STATE OF NORTH CAROLINA
DEPARTMENT OF TRANSPORTATION

December 16, 2011

Subject: **Permit Modification Request for the Individual Section 404 Permit, Individual Water Quality Certification, and CAMA Permit** for the widening of US 158/NC 34 from East of Pasquotank River to the US 158/ NC 34 split in Camden County. Federal Aid Project No. STP-158(2), Division 1, TIP Nos. R-2414 A&B. Debit \$670 from WBS 34430.1.1.

Please see the enclosed revised permit drawings (Sheets 1, 14, 15, 16, 17, 29, 30, 31, 32 of 38), roadway drawings, and revised EEP Acceptance Letter for the above referenced project. Due to the continual rejections of bids by contractors due to the stabilization methods, the NCDOT has redesigned the soil stabilization method which has resulted in impact changes at the three culvert locations on the above referenced project. Due to these changes, a permit modification is requested by the Department.

Sheet 15 of 38

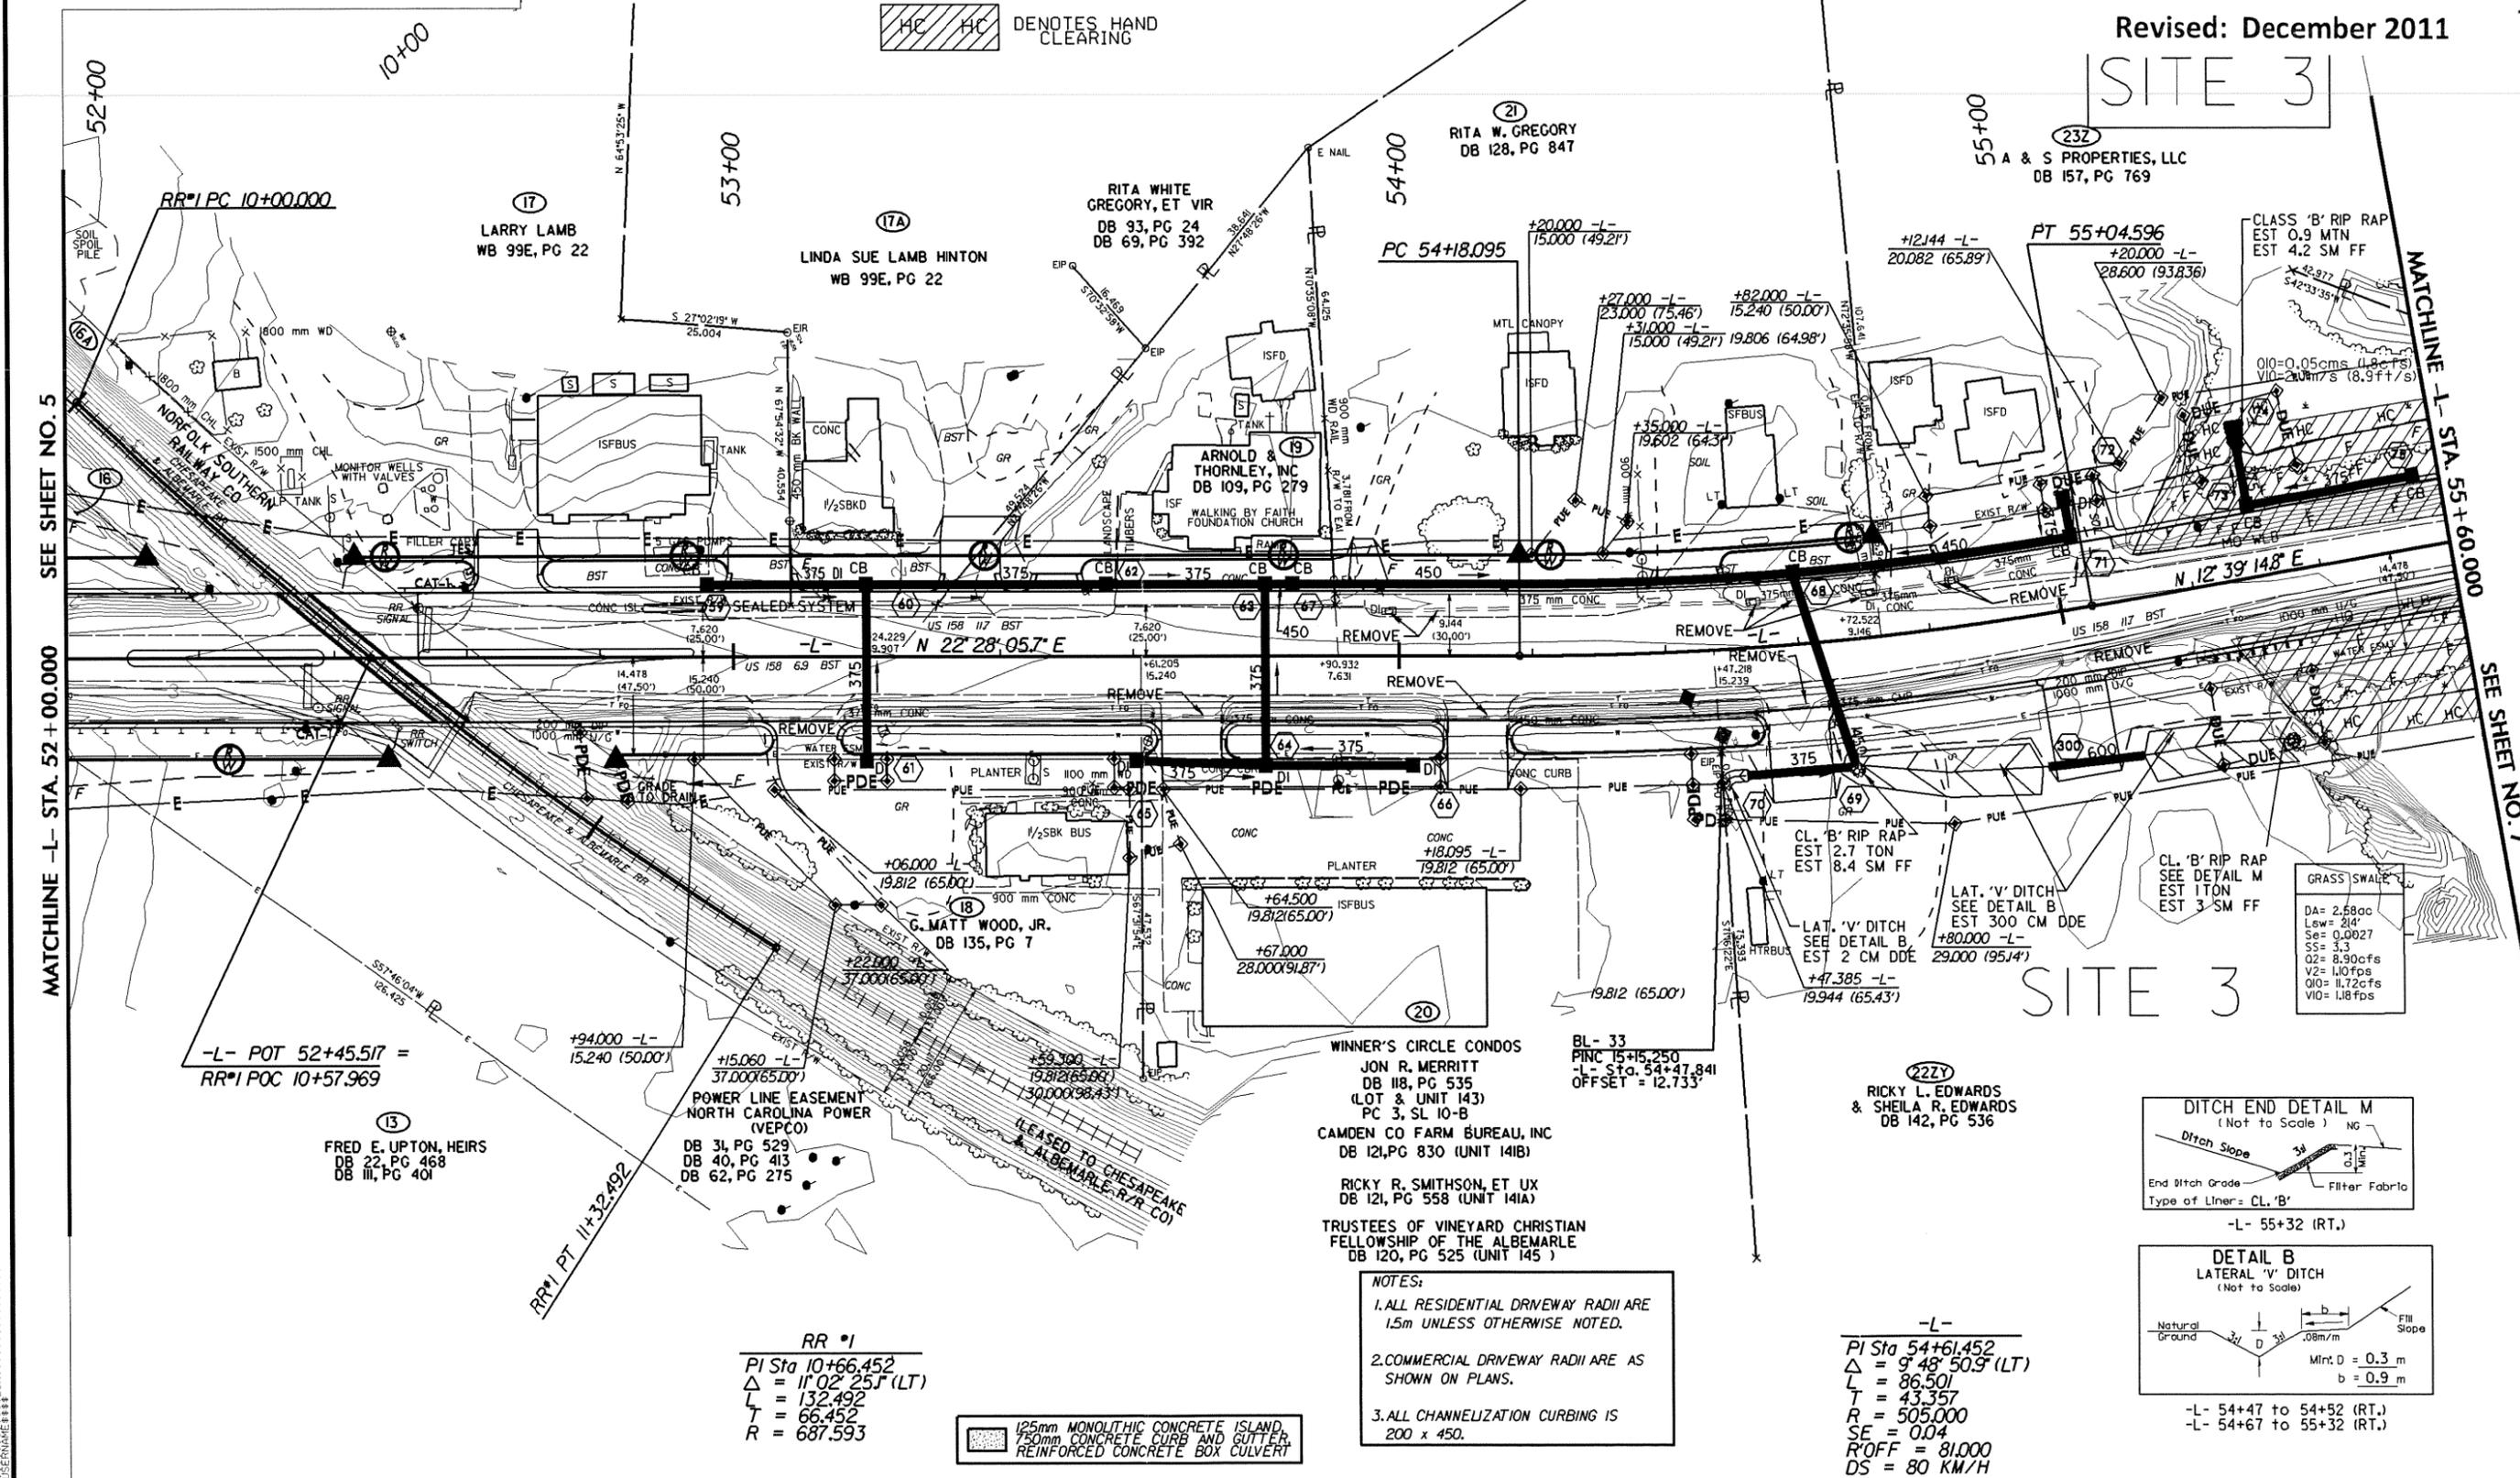
Site 3

The fill slopes will be expanded into a wetland area previously permitted as hand clearing. However, the hand clearing limit will not be expanded at this location. As a result, the permanent fill in wetlands will increase from 0.65 to 0.67 acre, and the hand clearing impact will be reduced from 0.26 to 0.24 acre.

The culvert type has also been reverted back to a single barrel 8’ by 6’ reinforced concrete box culvert (RCBC), as this stabilization method obviates the need for the lightweight aluminum.
